Engineering Review

**FINAL DRAINAGE REPORT  
FOR  
RETREAT AT TIMBERRIDGE  
FILING NO. 2**

PCD-ENGINEERING REVIEW COMMENTS  
IN BLUE BOXES WITH BLUE TEXT

PCD Project No. SF-21-XXX

DETENTION FACILITY POND 3

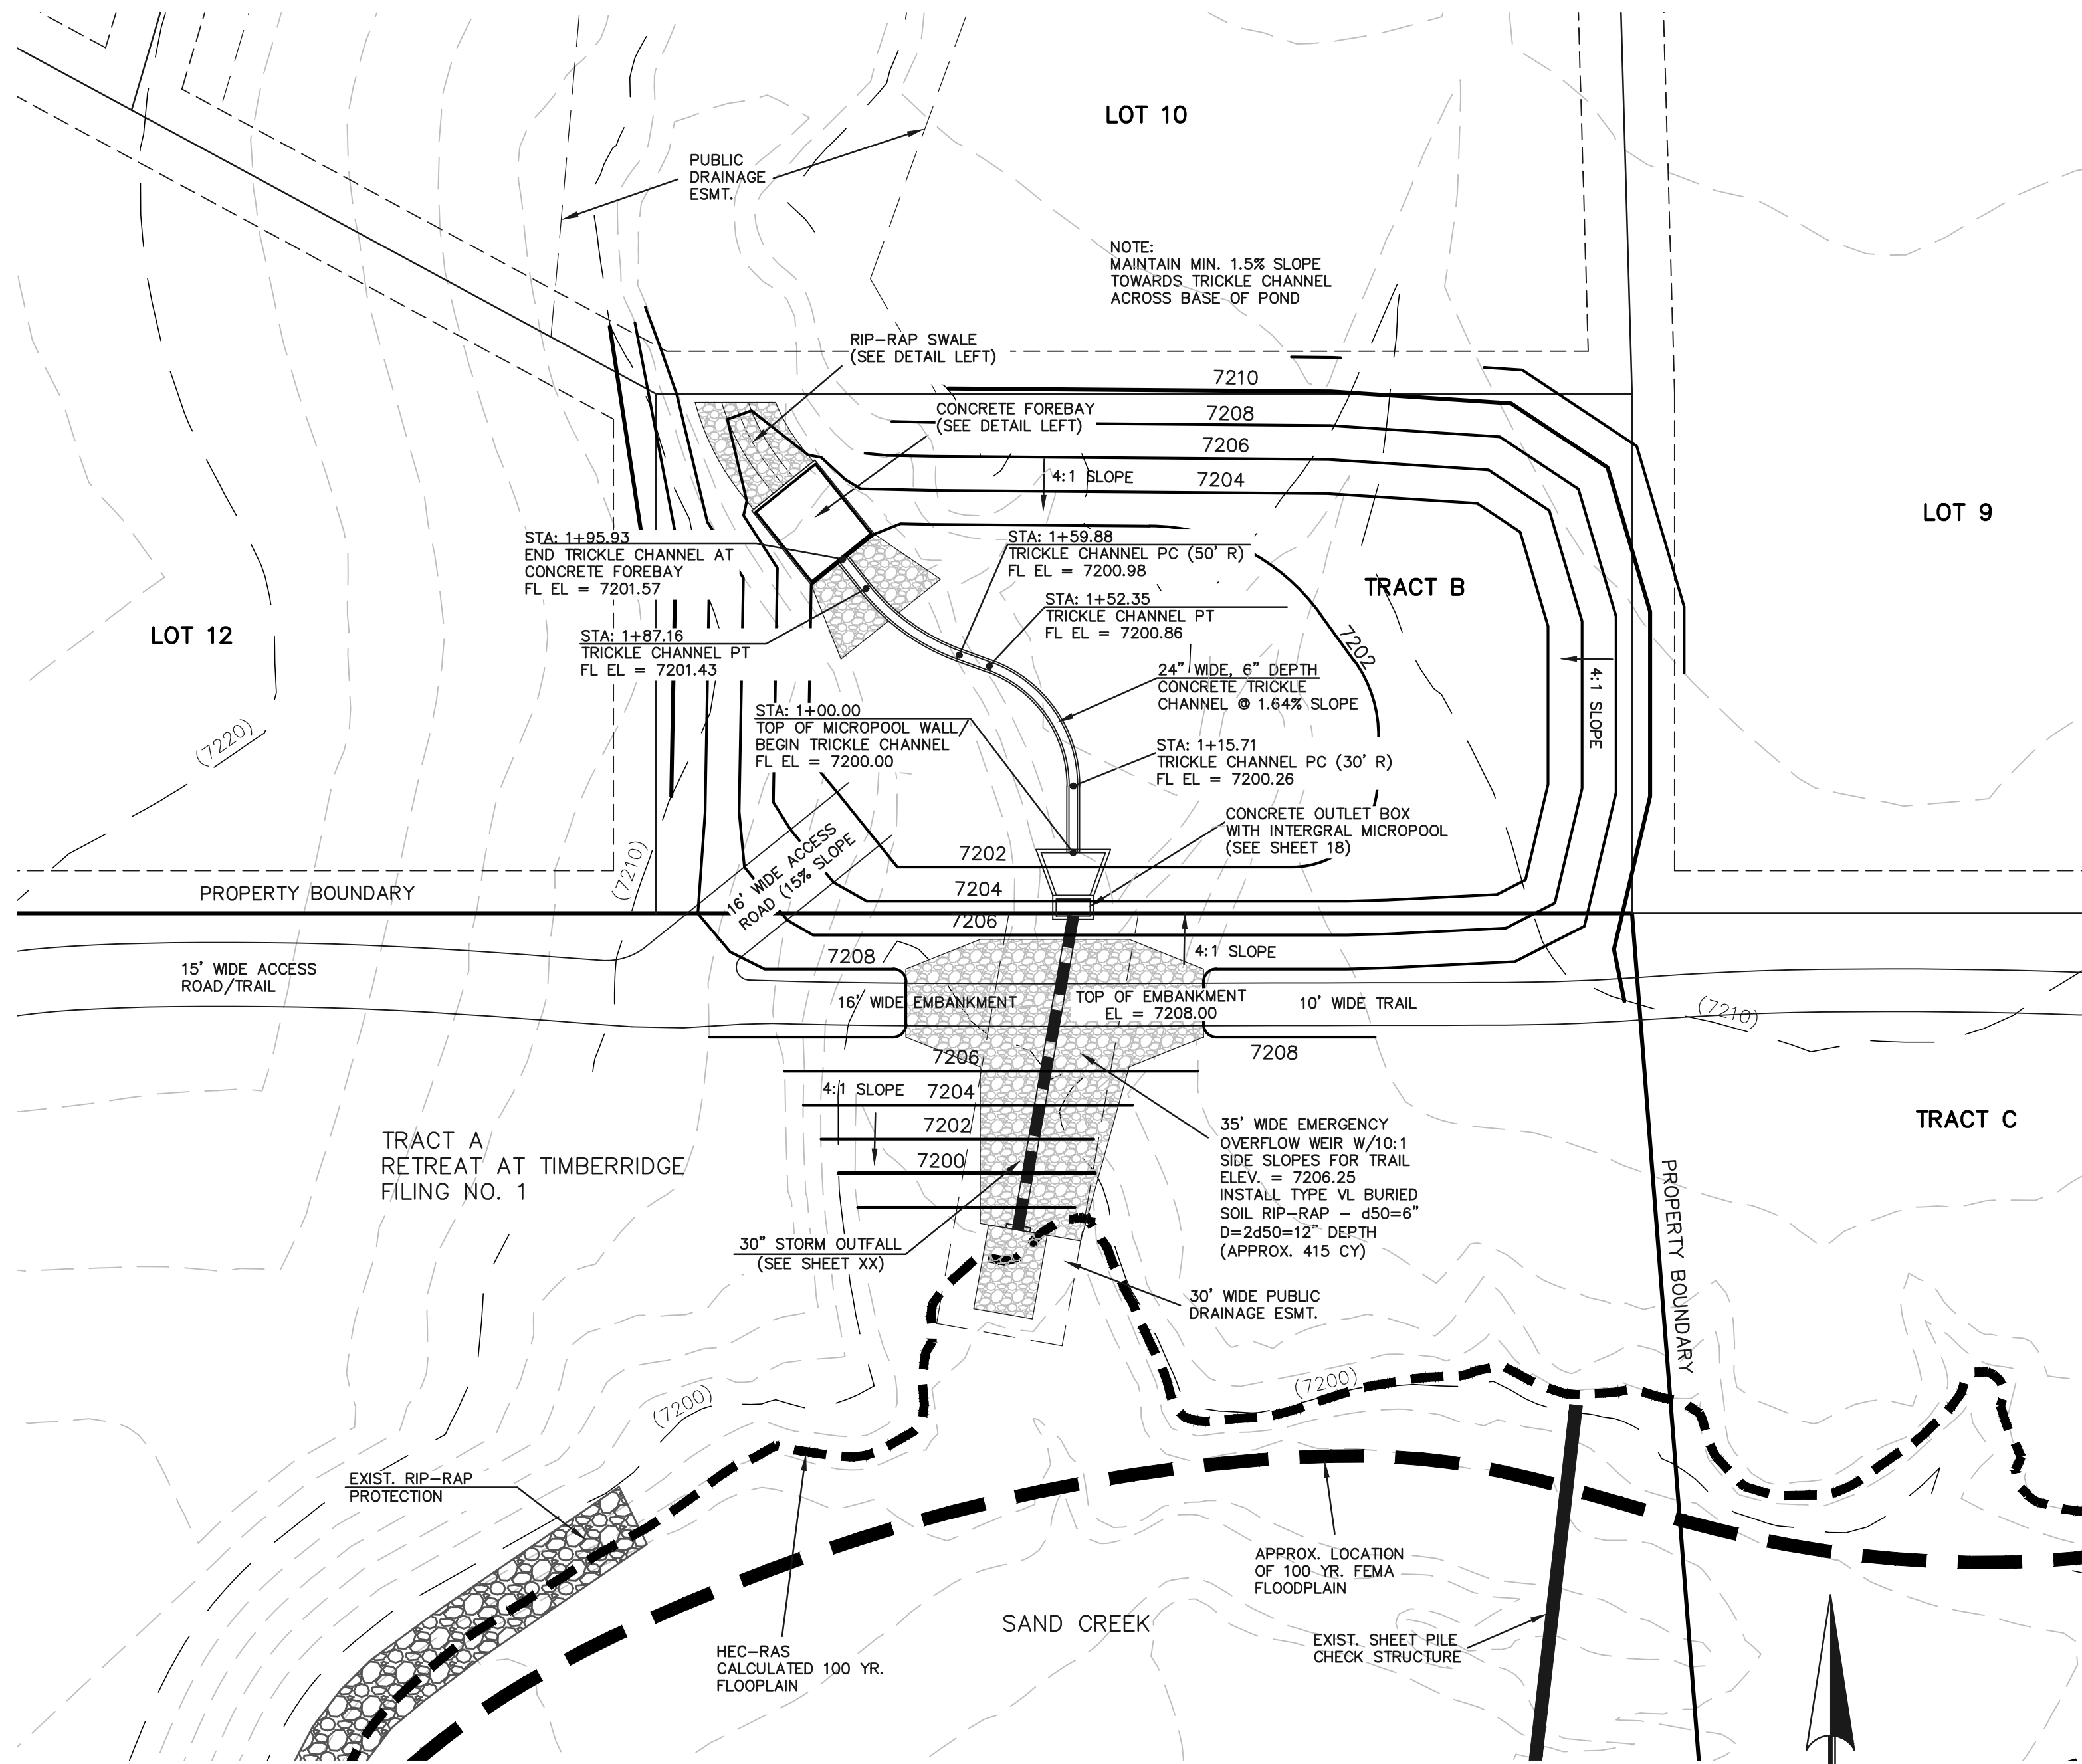
See comment letter regarding location of the pond
